Planning Application Ref: AW/171/18/T

Location: 6 Seacourt Close, Aldwick, PO21 4RD

Description of works: 3m Crown Reduction to 1No. Oak tree

OAK
TREE

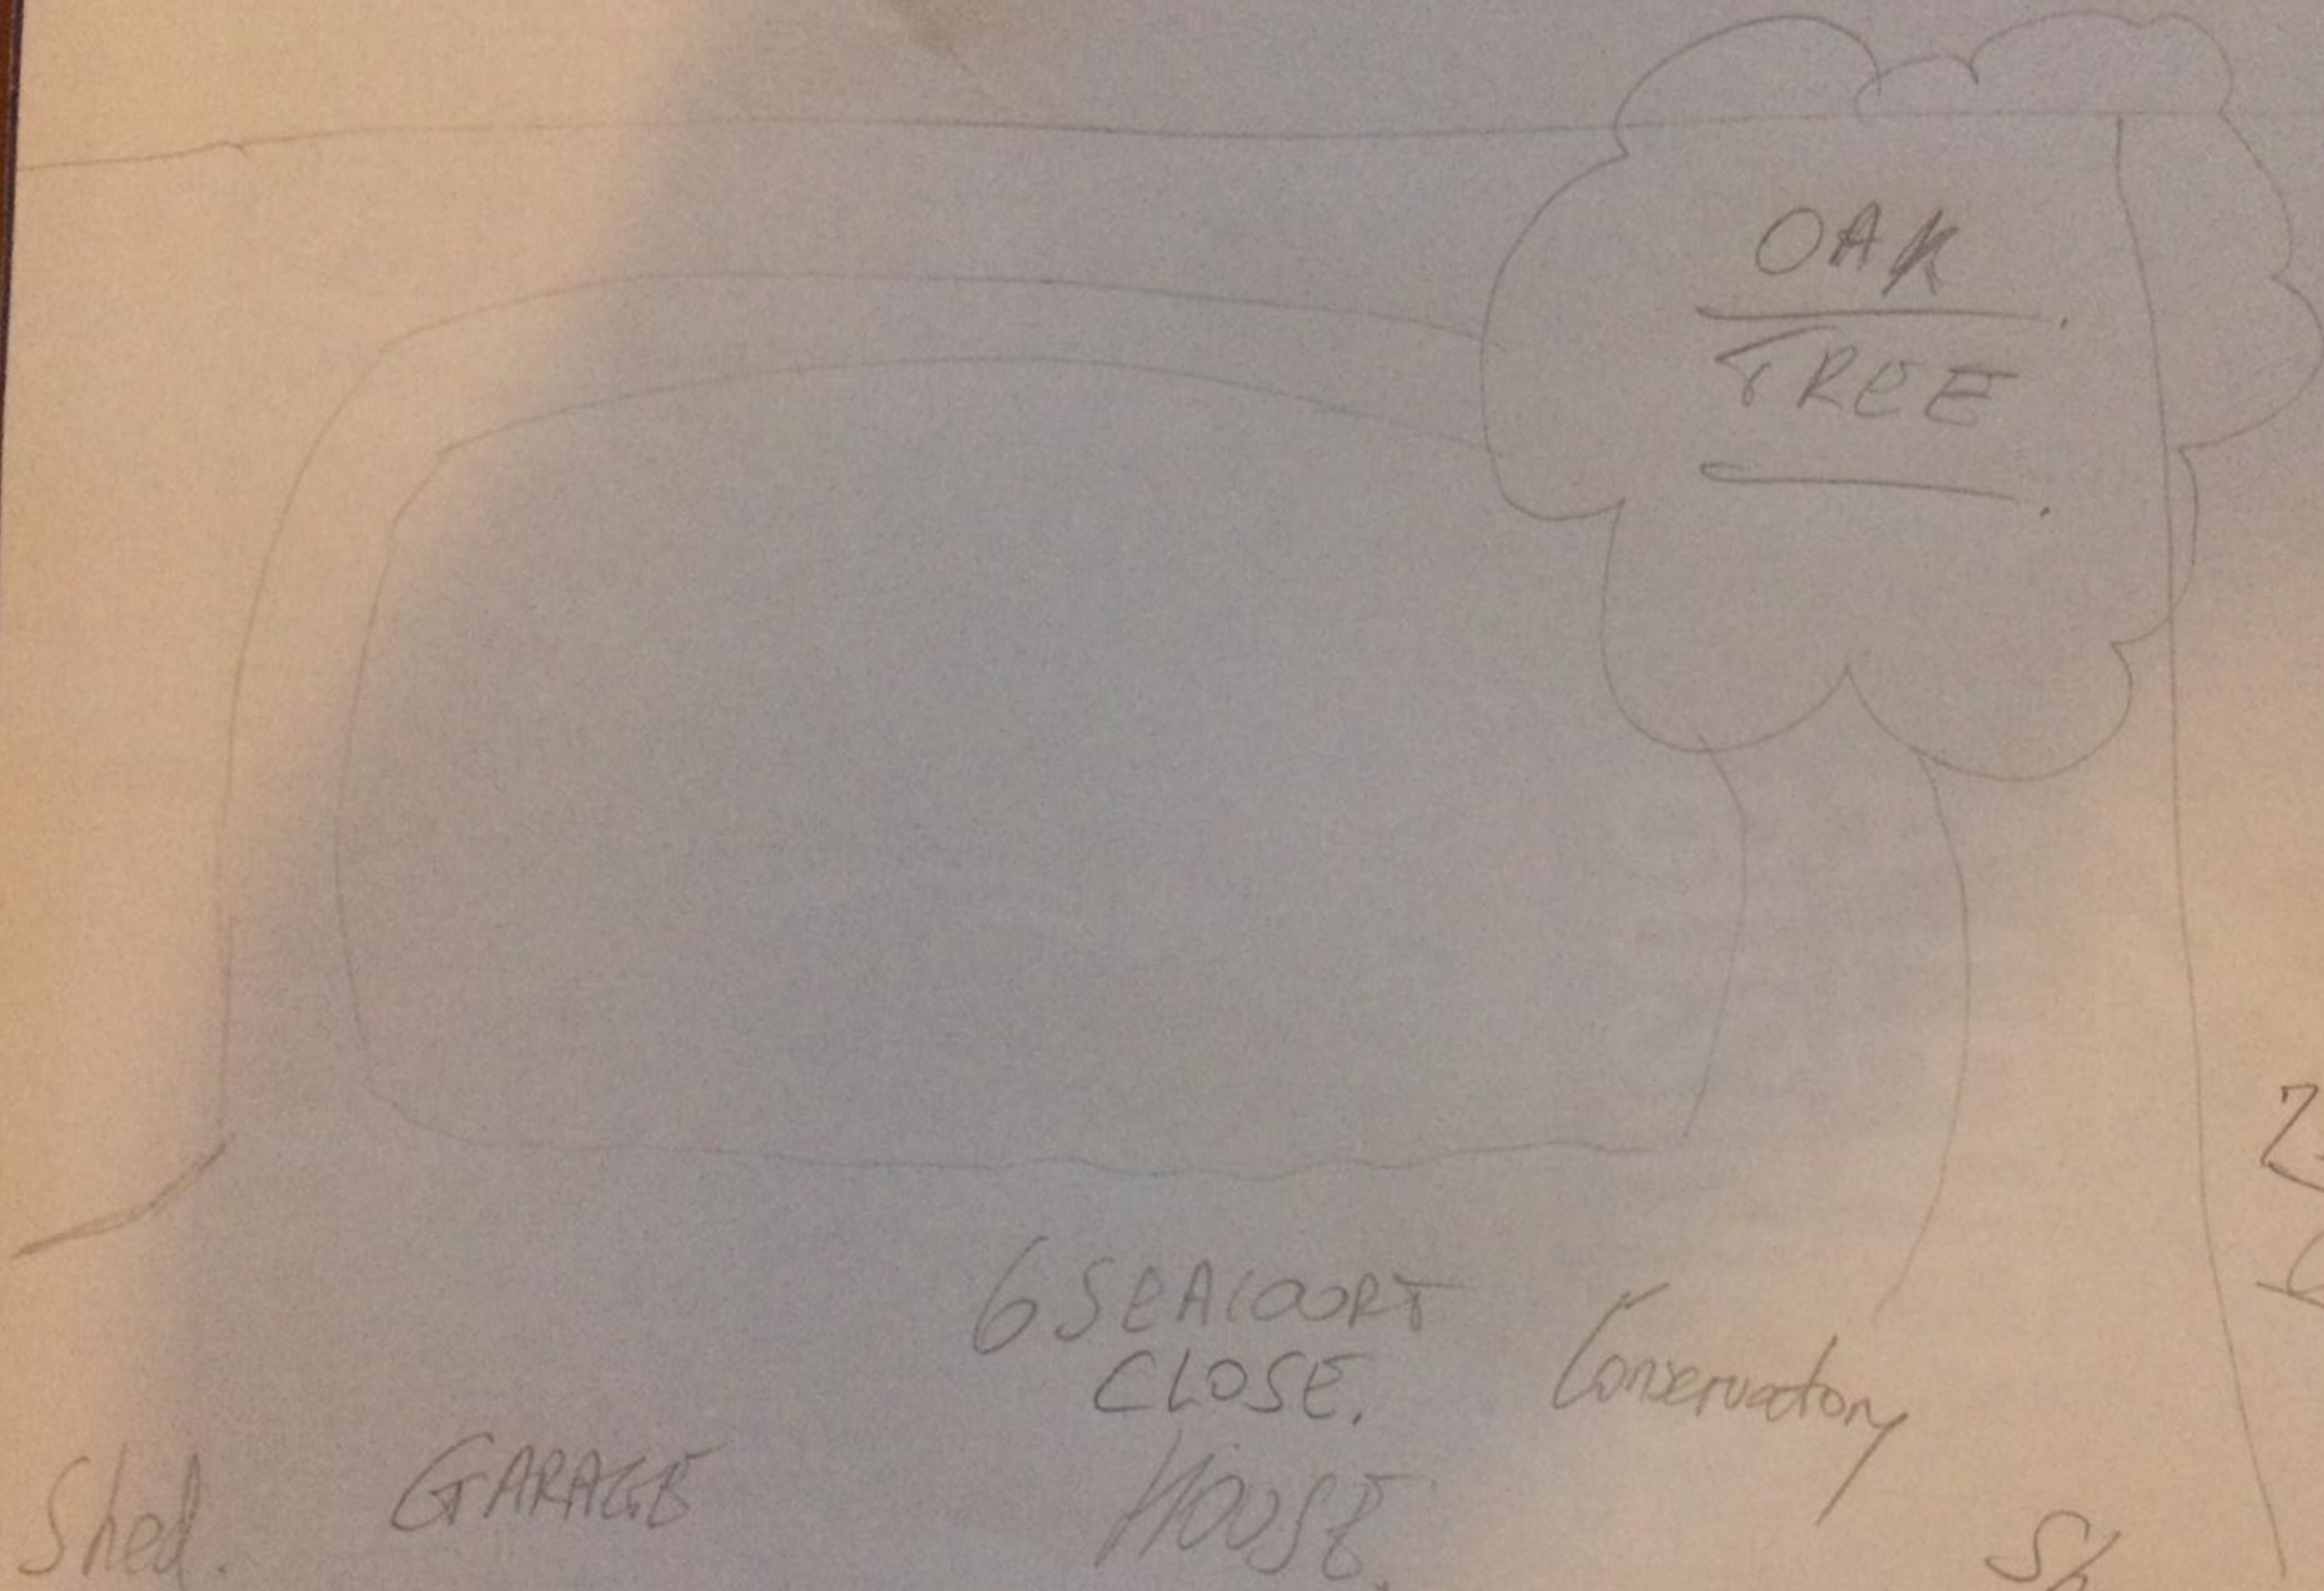
- The nearest point of built structure is a conservatory along the rear elevation of 6 Seacourt Close, at a distance of approximately 10metres from the tree.

- It has not been demonstrated (nor evidence provided in support of) that this tree requires crown reduction work on arboricultural grounds. I see no obvious risk of damage to built structures at this time. Although the boundary fence lines are in varying states of disrepair they are both intact and functional with scope to accommodate main stem expansion as the tree grows.
- The tree already represents a visual amenity and has potential to develop into a significant feature in the local landscape. It appears to be in adequately sound and healthy condition. The tree surgery proposed in the application would result in excessive reduction of the tree's current value and curtail its potential, thereby constituting an undue detriment to the visual amenities of the locality.

- I recommend **REFUSAL** for this application.
